# CITY OF ALBUQUERQUE

January 11, 2016

**RE: Smith's #423 Fuel Center  
Grading and Drainage Plan (Stamp Date 11/16/2015)  
Hydrology File: F14D072**

Storm Drain Connection - Gene Street

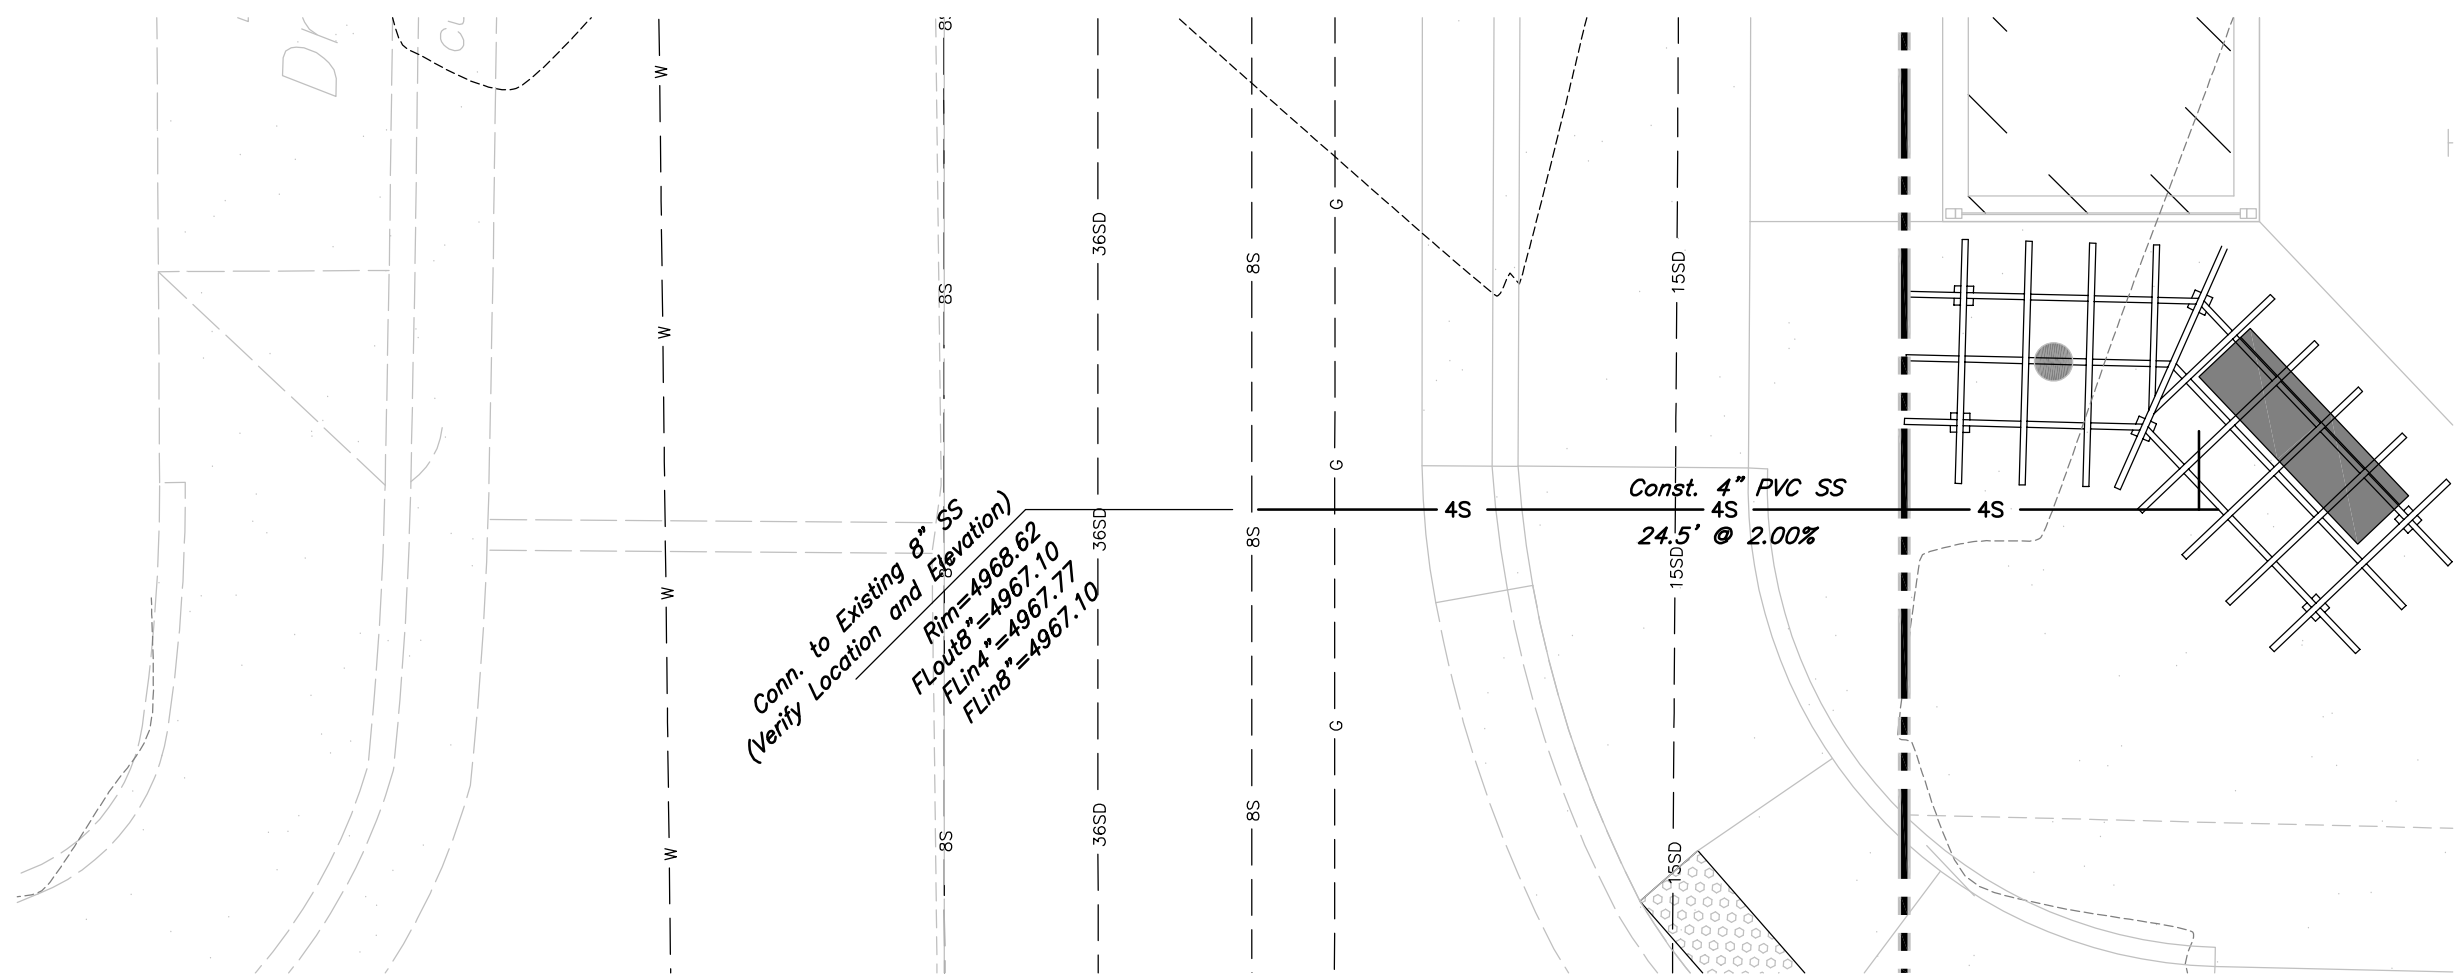
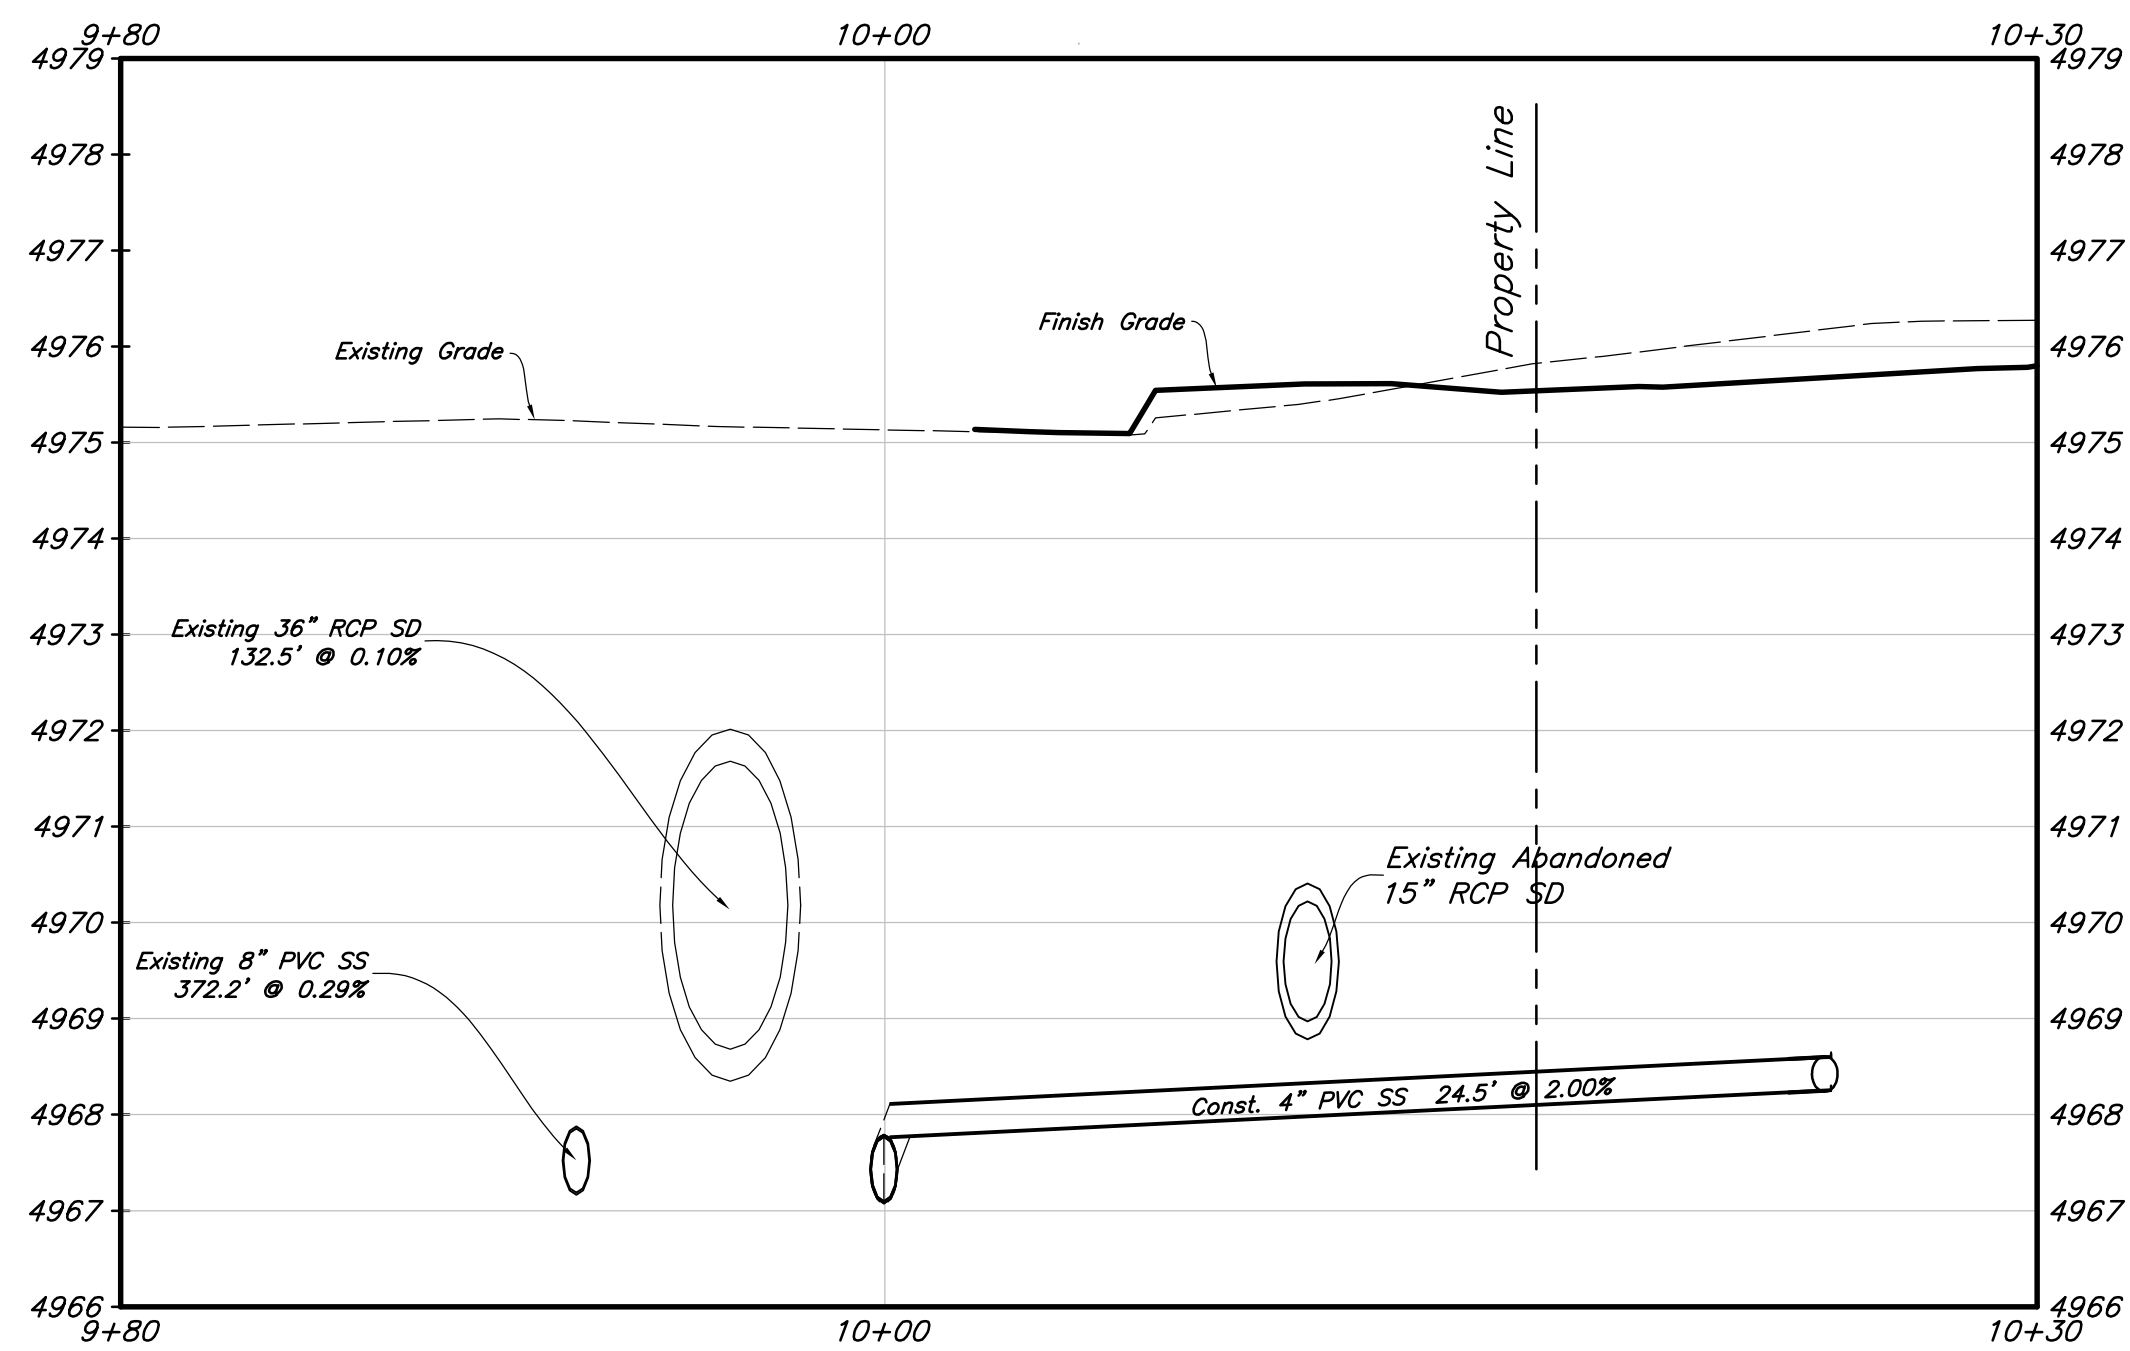
- a. The connection to the 36" storm drain cannot be direct; a manhole needs to be constructed (to City standards).
  - b. The City does not allow PVC pipe for storm drain in the right of way, you would need to transition to RCP, or HPPP (High Performance Polypropylene Pipe).

14 StormTech MC-4500 Isolator Row Detail
Not to Scale

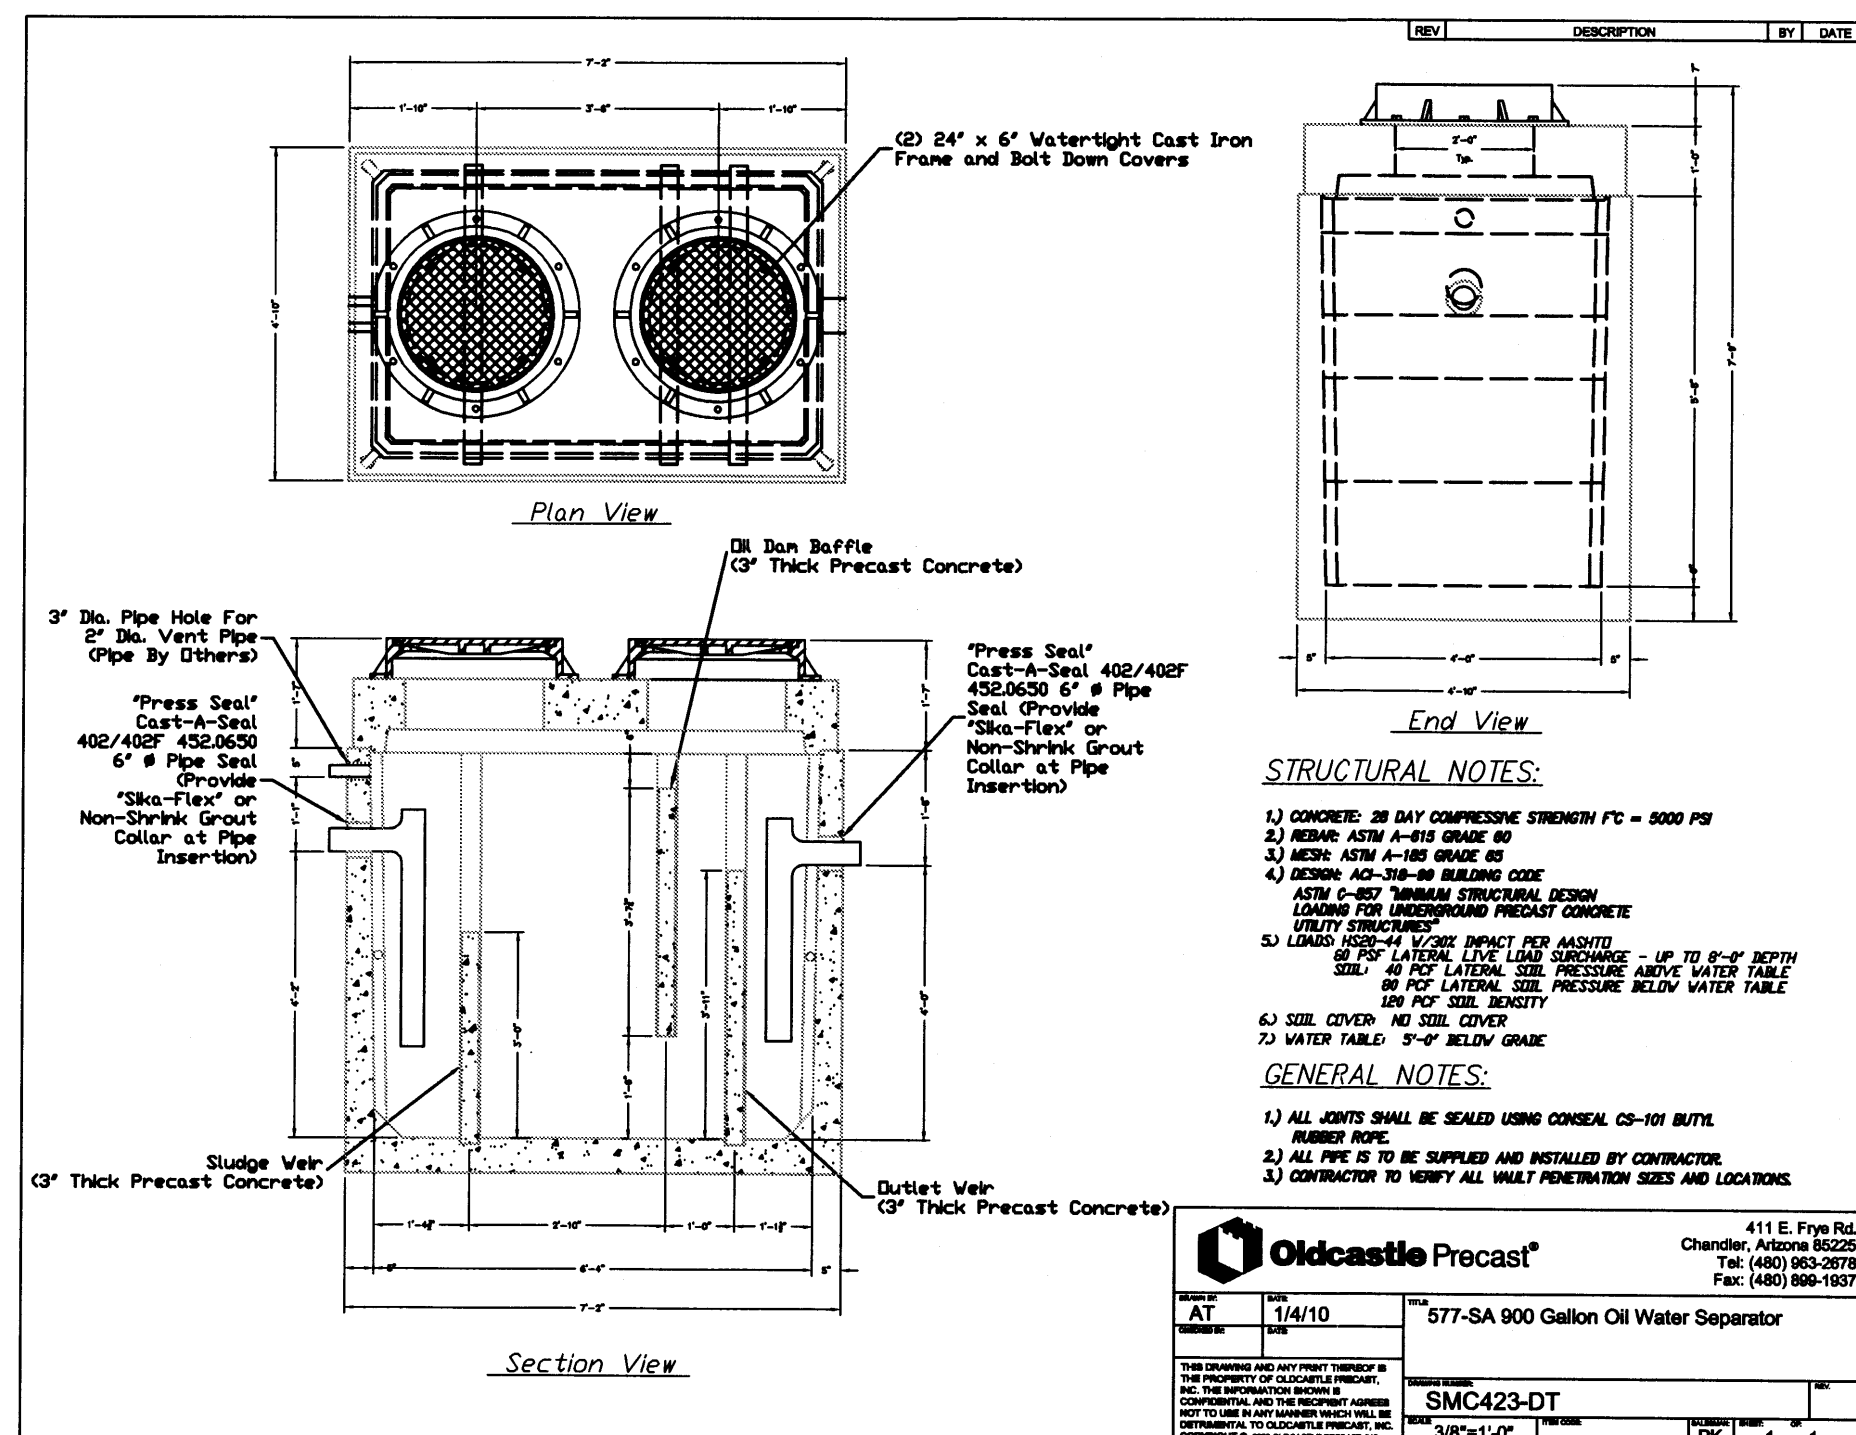
3. The detail for the Stormtech chambers appears to show elevations that don't match this project.

13 Oldcastle Precast
Oil / Water Separator 577-SA
900 Gallon - API Style
Not to Scale

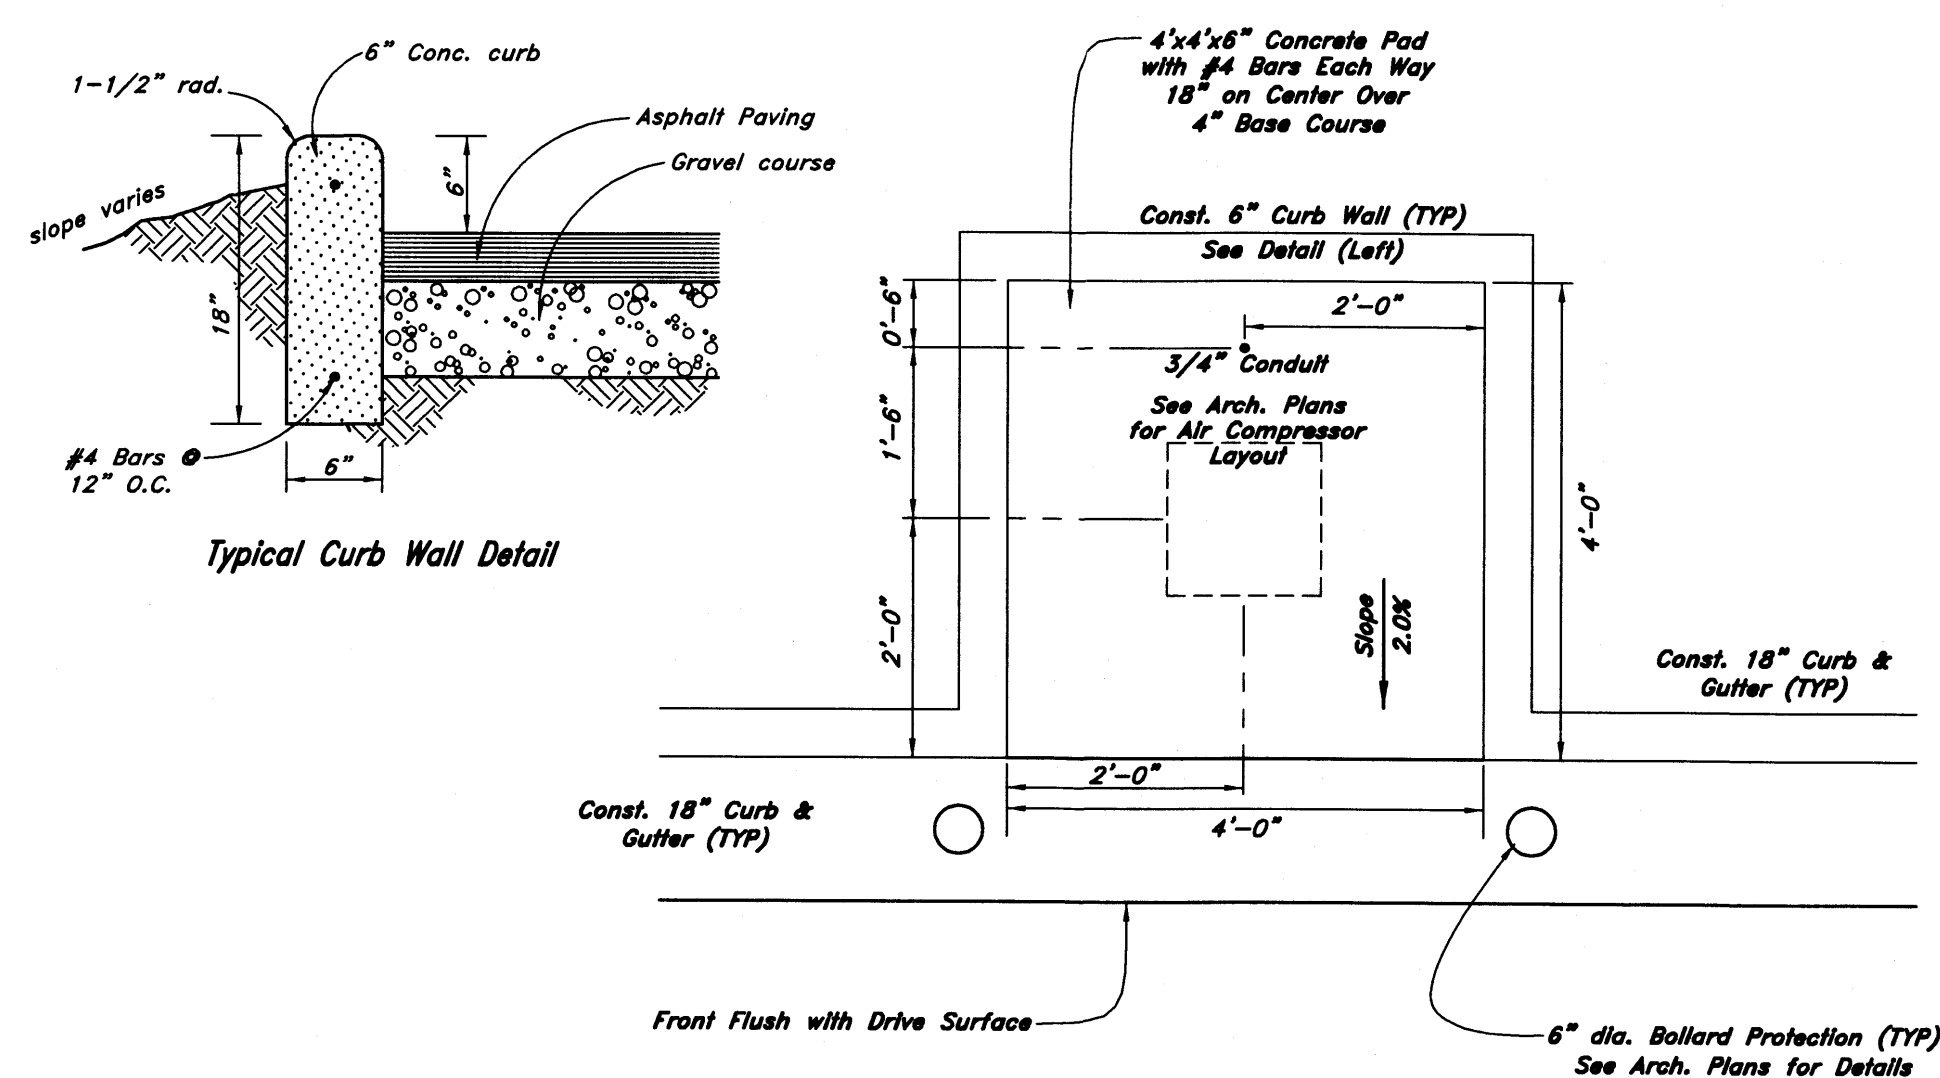
- c. For your reference, the DRC set will need to show that the gas line and other utilities do not conflict with the new pipe under Gene Avenue.
2. A detail for a Snout is shown, but the reference on the plan for an oil/water separator is a Contech CDS. Where is the snout being used? If you do use the snout, show the approx. sump elevation and the approx. outlet elevation.
